WEST SUSSEX COUNTY COUNCIL CONSULTATION

TO:	Arun District Council FAO: Simon Davis
FROM:	WSCC - Highways Authority
DATE:	29 July 2021
LOCATION:	The Croft Surgery Barnham Road Chichester PO20 3RP
SUBJECT:	BN/62/21/PL Medical centre with pharmacy retail unit & other ancillary uses together with access onto Barnham Road, associated car parking and other hard and soft landscaping works. This site is in CIL zone 2 (Zero Rated) as other development. Transport Assessment, Travel Plan, Road Safety Audit, Designers Response & Access Plan amendments have been received.
DATE OF SITE VISIT:	n/a
RECOMMENDATION:	Advice
S106 CONTRIBUTION TOTAL:	n/a

Title:
Swept Path Analysis
Large Refuse Vehicle

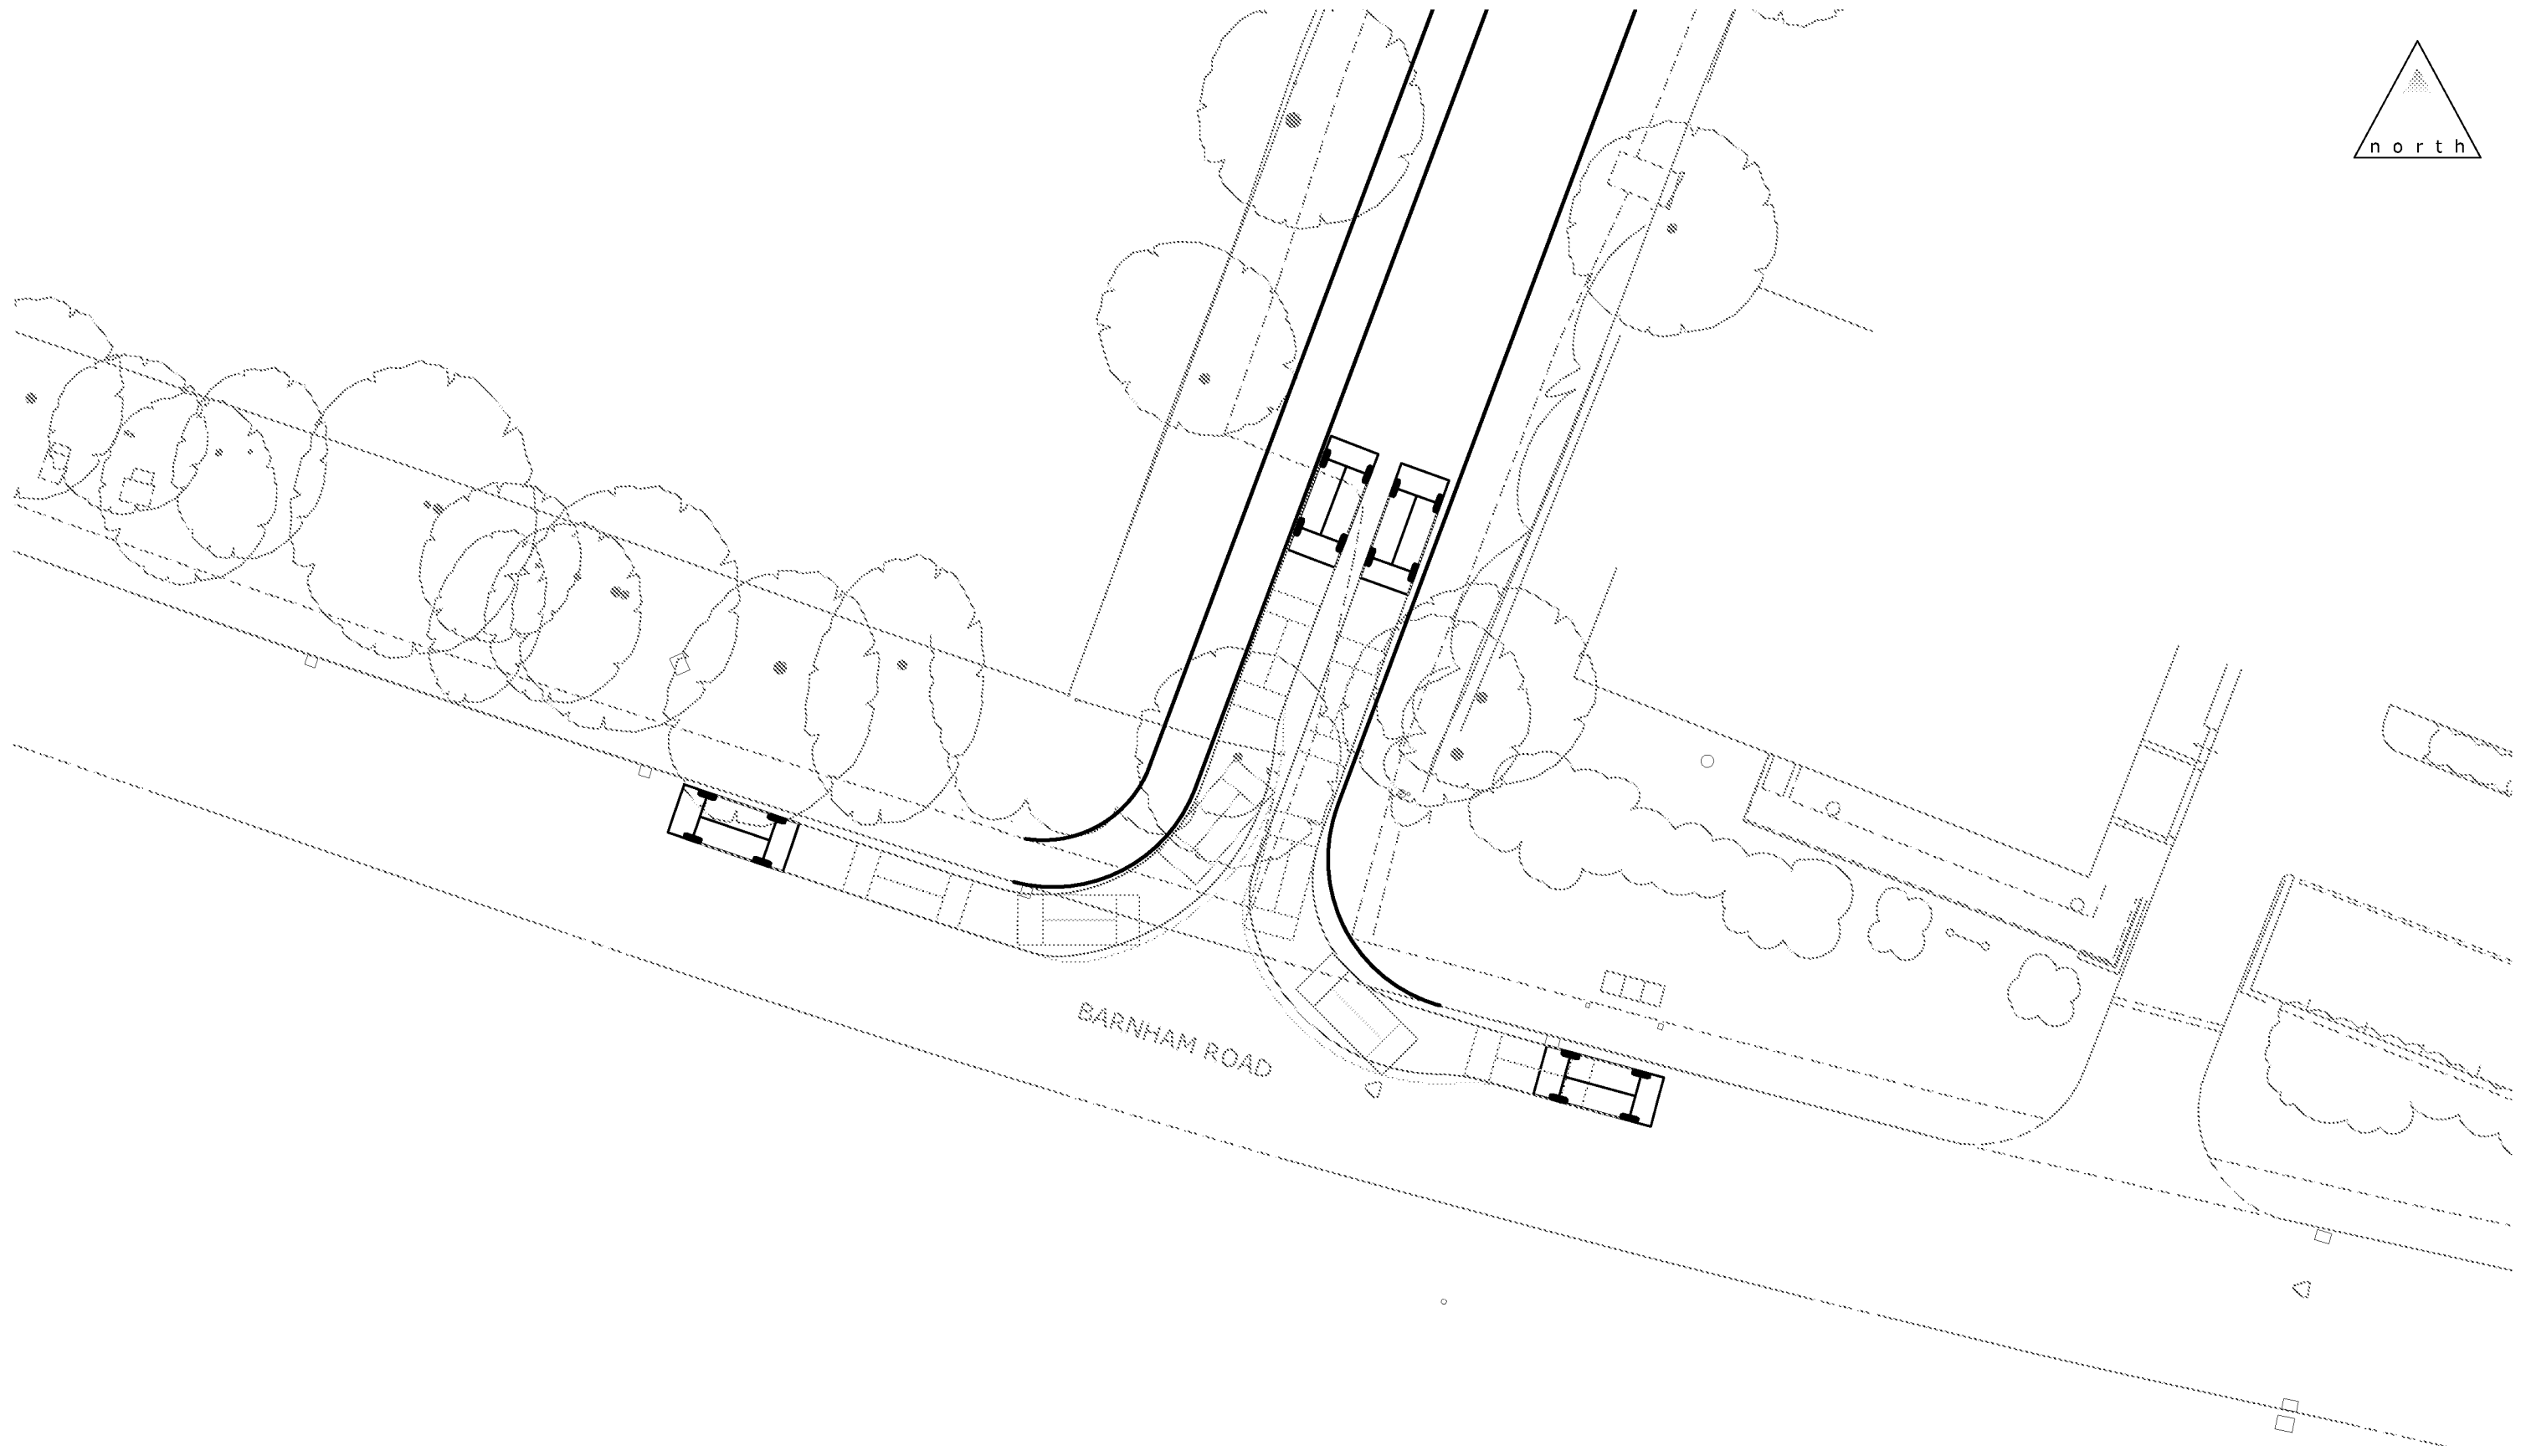
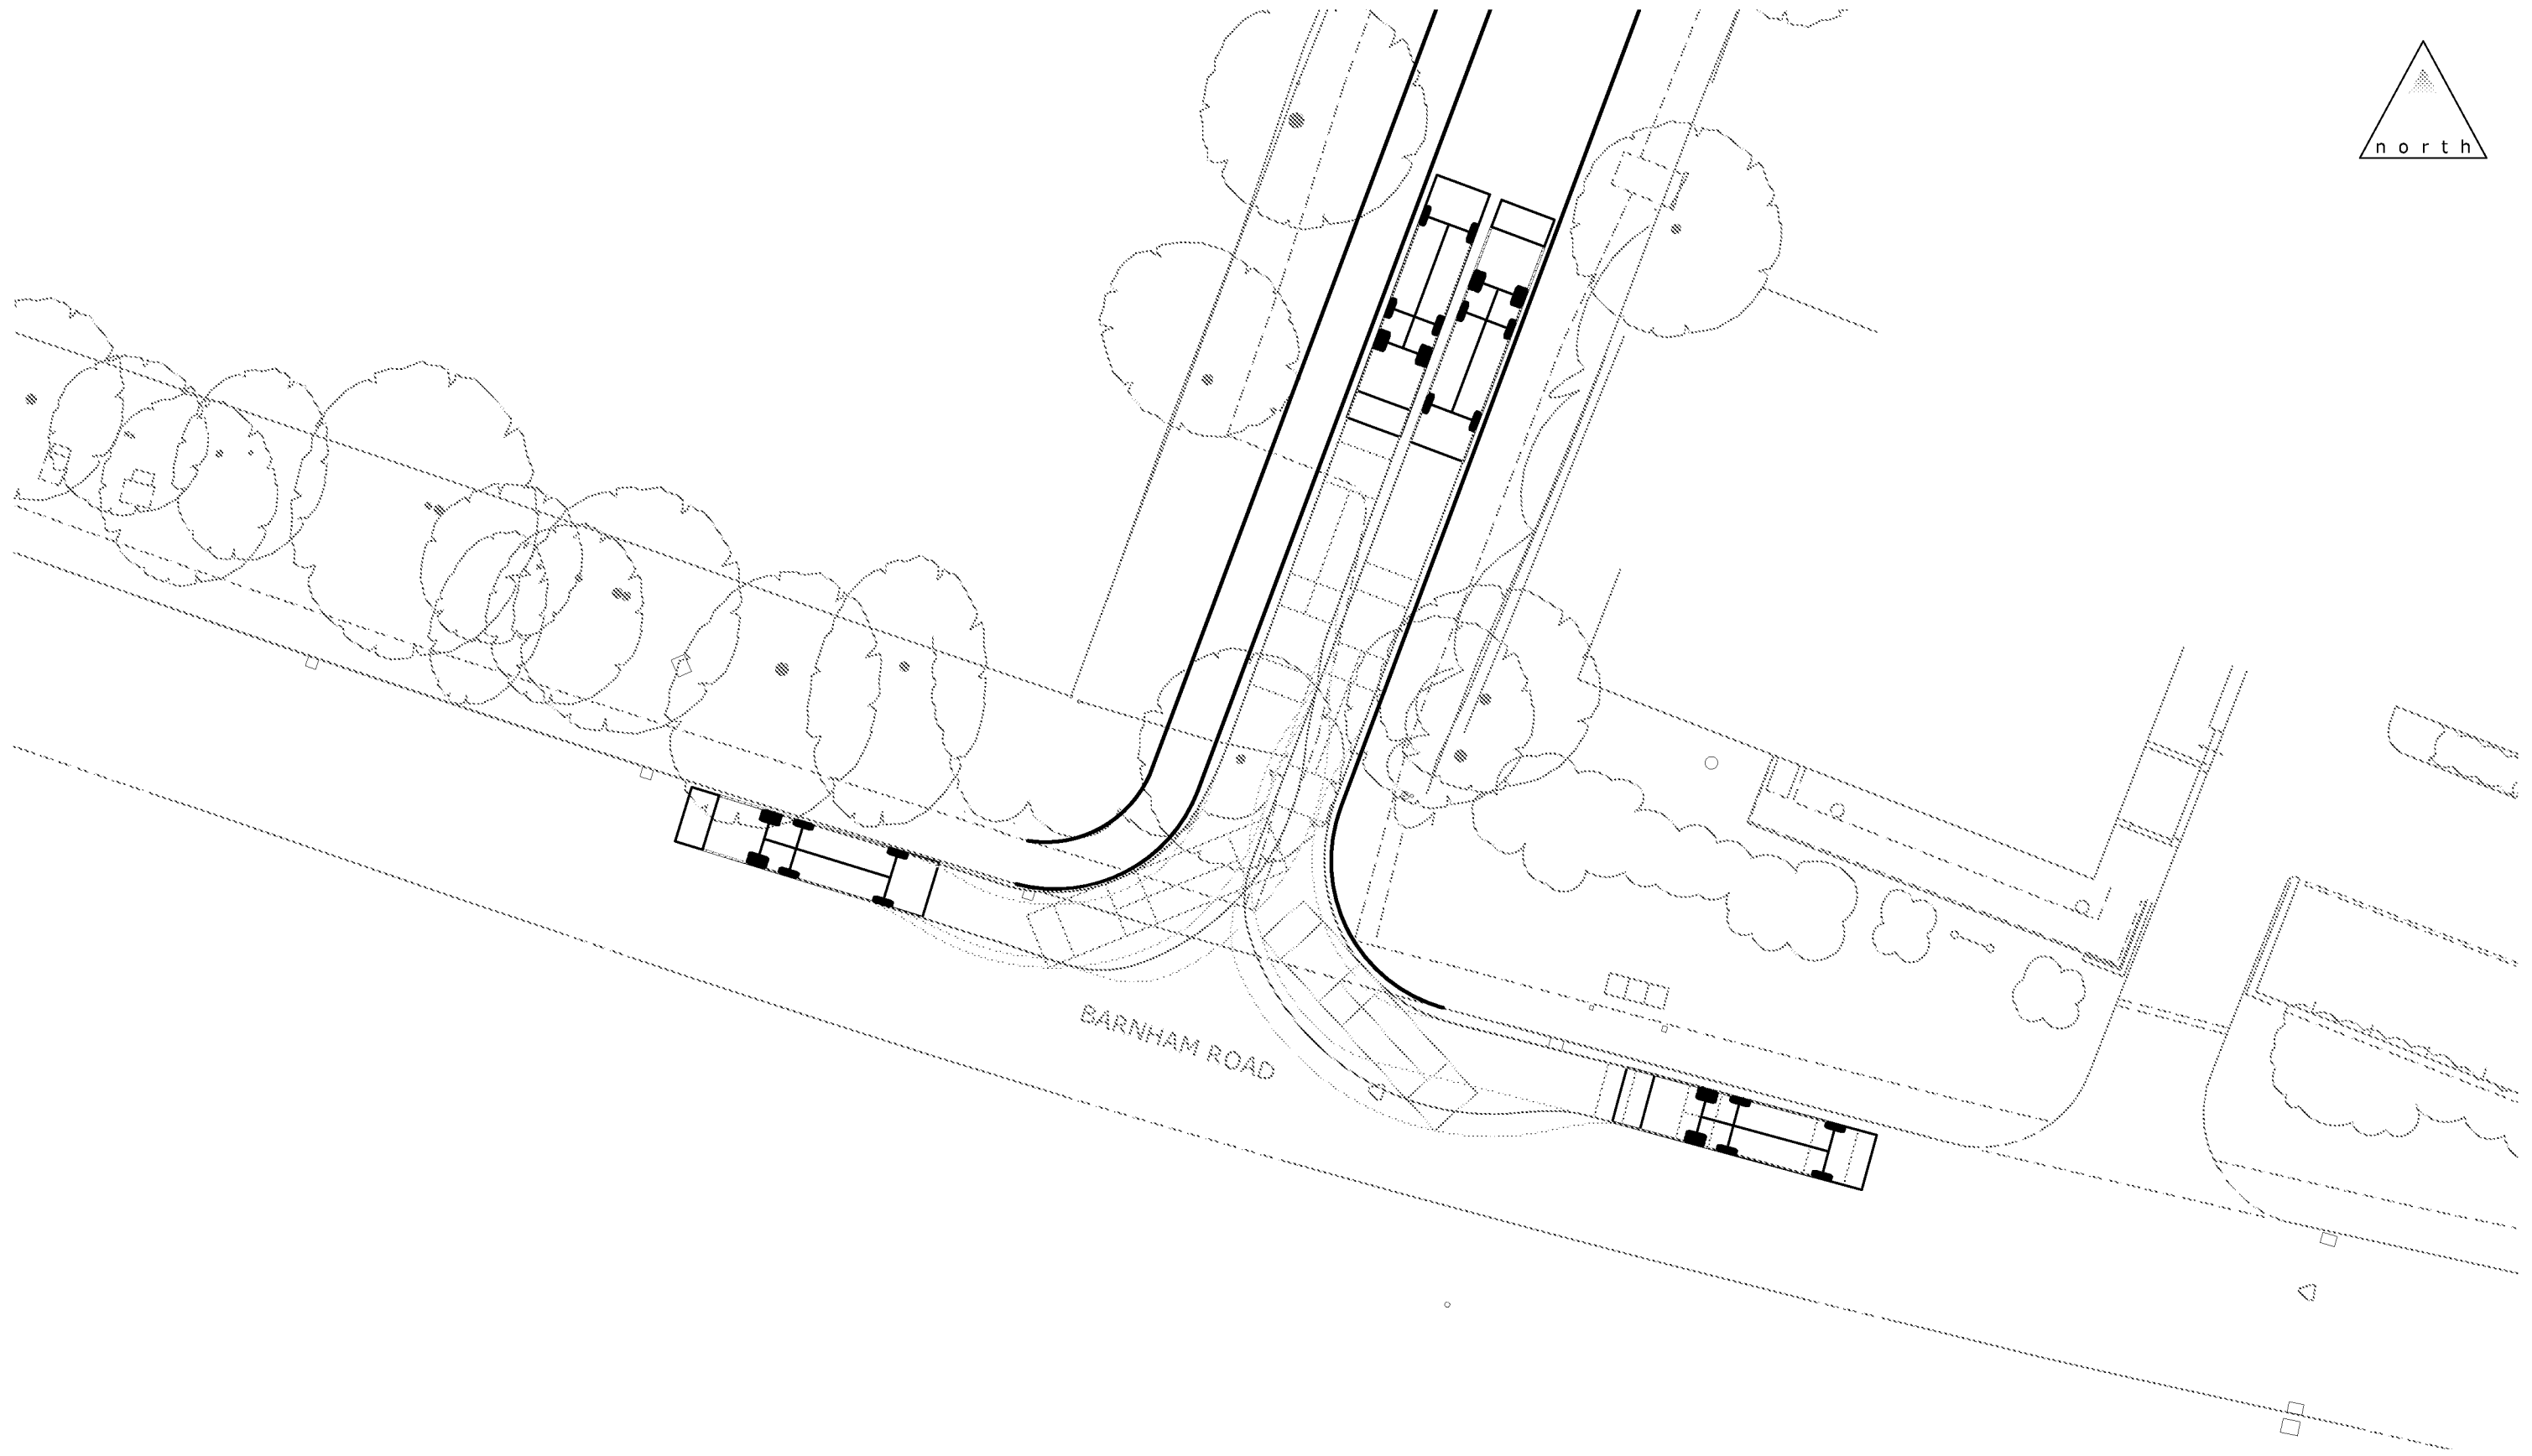
Swept path tracking has been provided demonstrating that a refuse vehicle can enter and exit the site, and turn within the safe safely. There is sufficient space within the access and internal access way for two large vehicles to pass.
